Seeger Homes, Inc. – Sales Office @ Lot 3 in Appaloosa Highway 24 Subdivision
Letter of Intent

Site Location: Lot 3 in Appaloosa Highway 24 Subdivision
Colorado Springs, CO 80915

Add PCP File No. PPR1831

SALES OFFICE
DEVELOPMENT PLAN

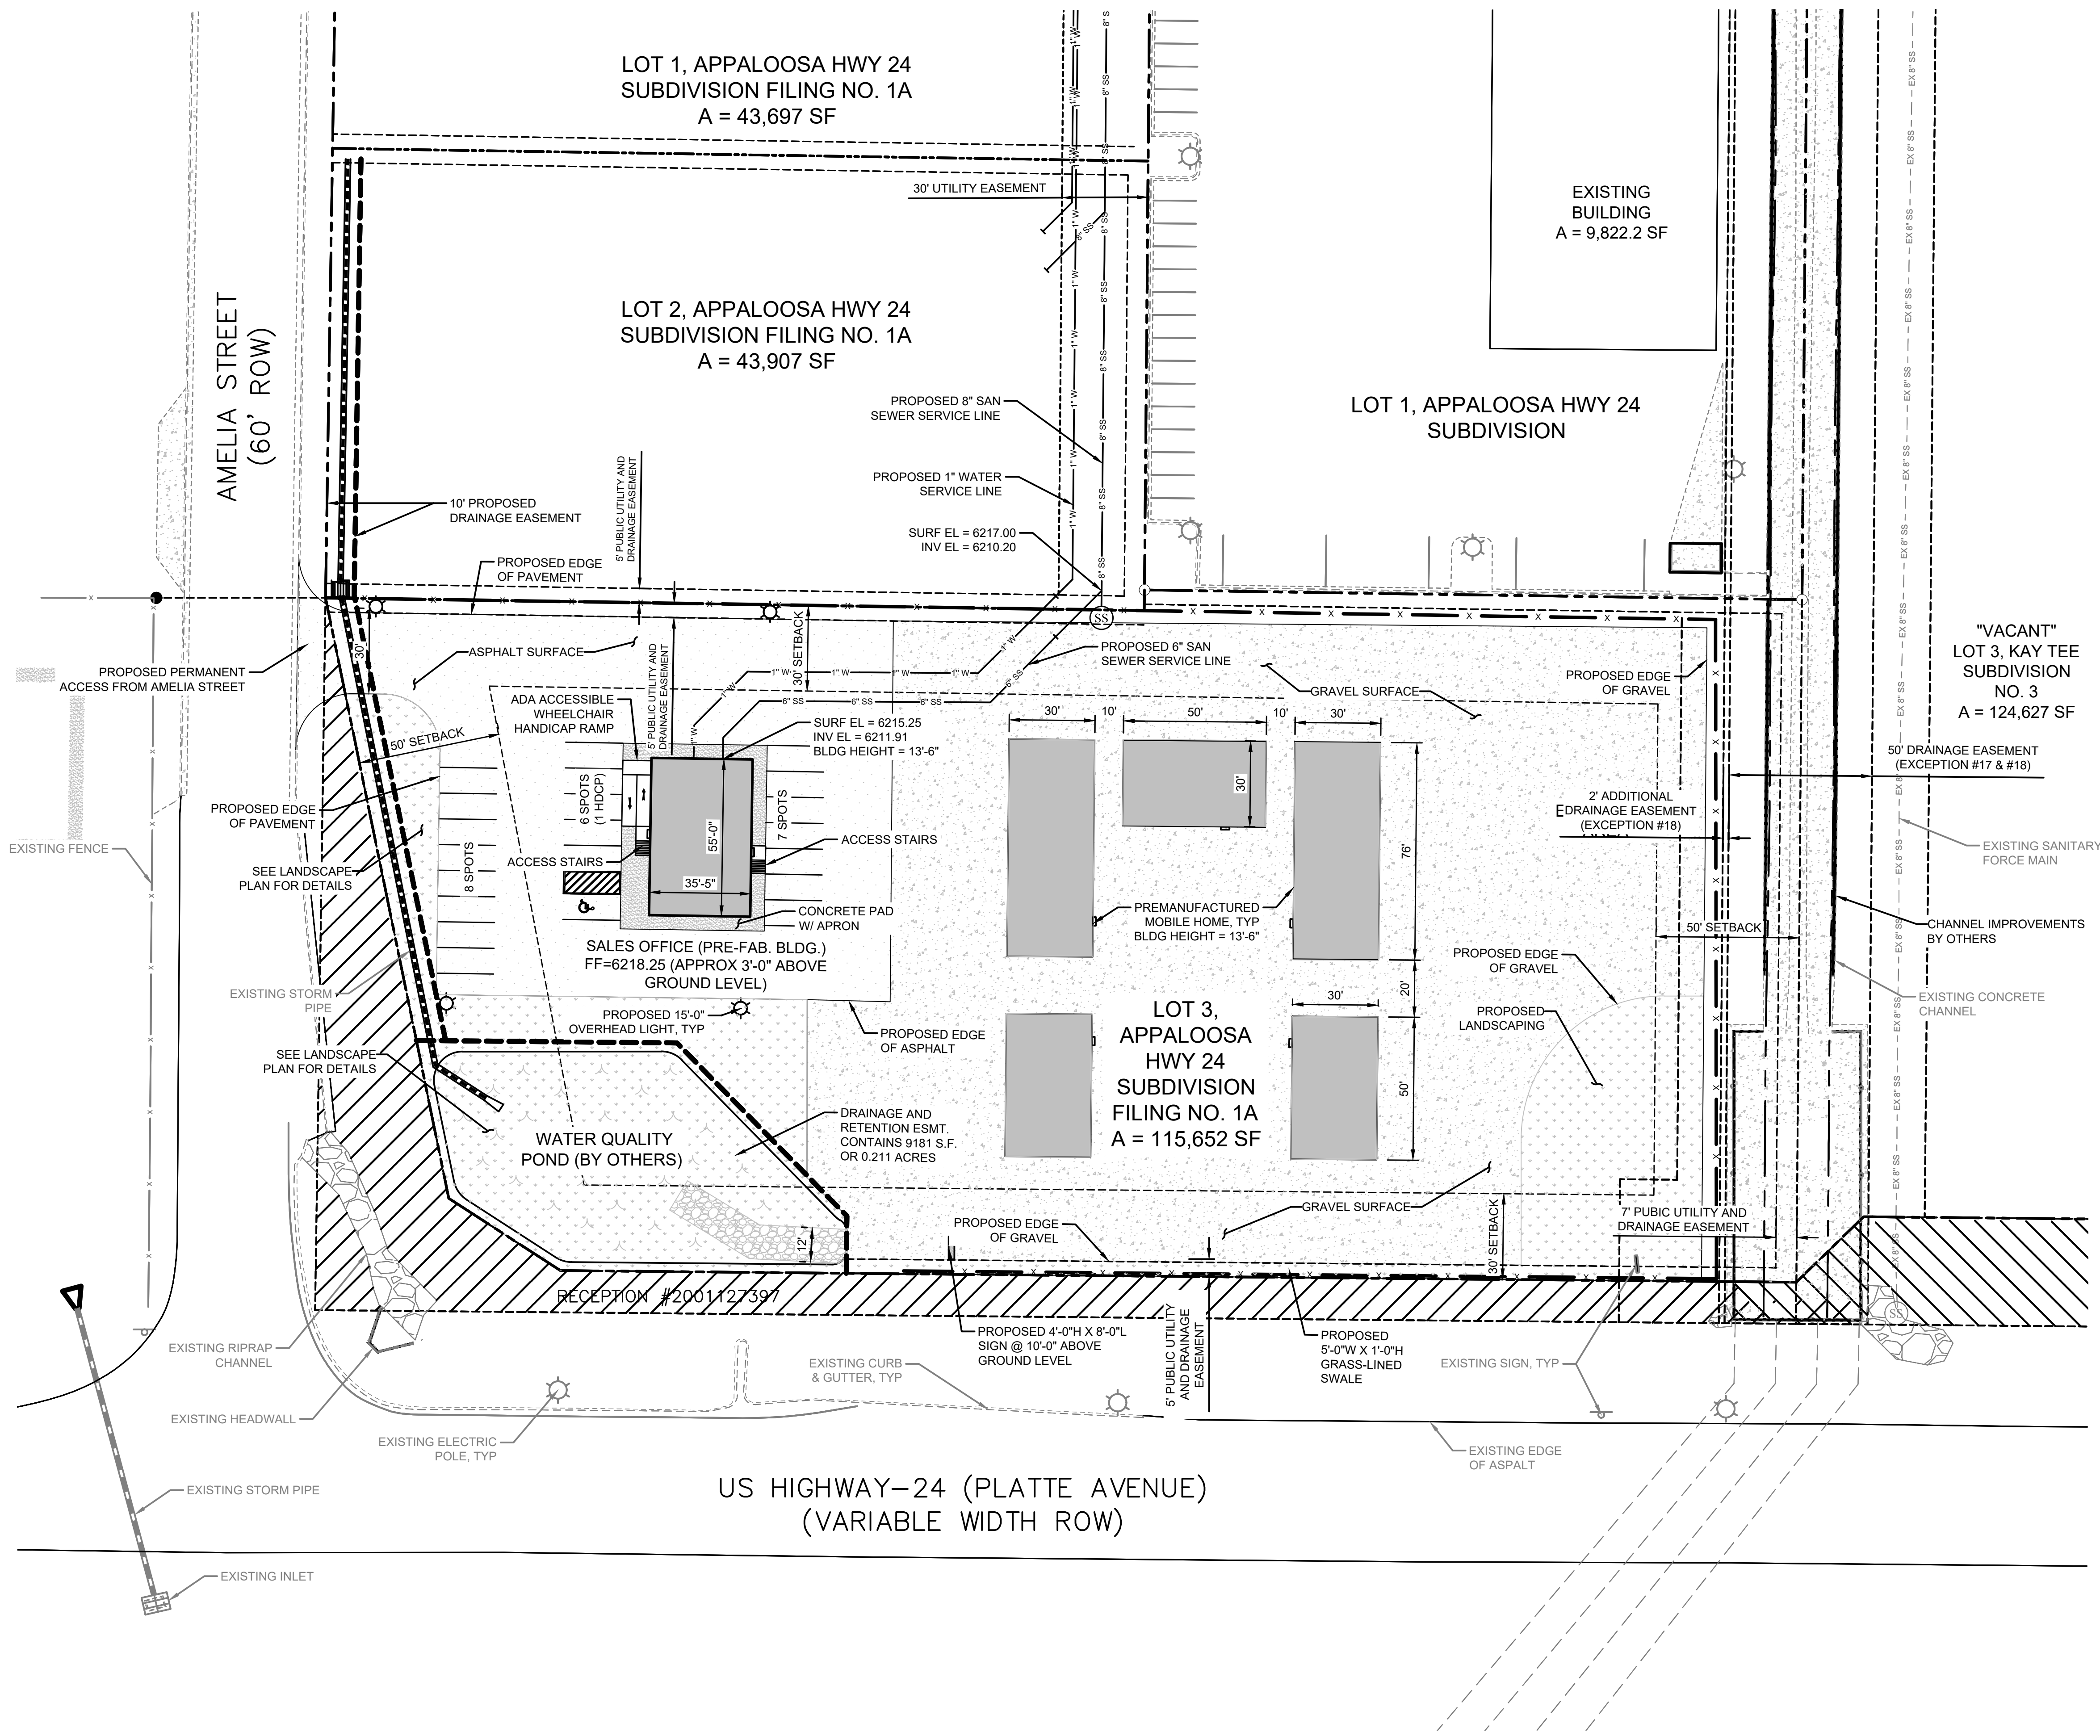
State who will own and maintain the water quality facility. FYI a CO will not be issued for this site until the water quality facility is installed.

If you are asking for an alternative landscape request you have to show it here and on the landscape plan.

It is not an internal private access parcel. You are anticipating access off Amelia Street. Please discuss in this section. Please address CDOT adjacent to the site. Provide any correspondence with CDOT
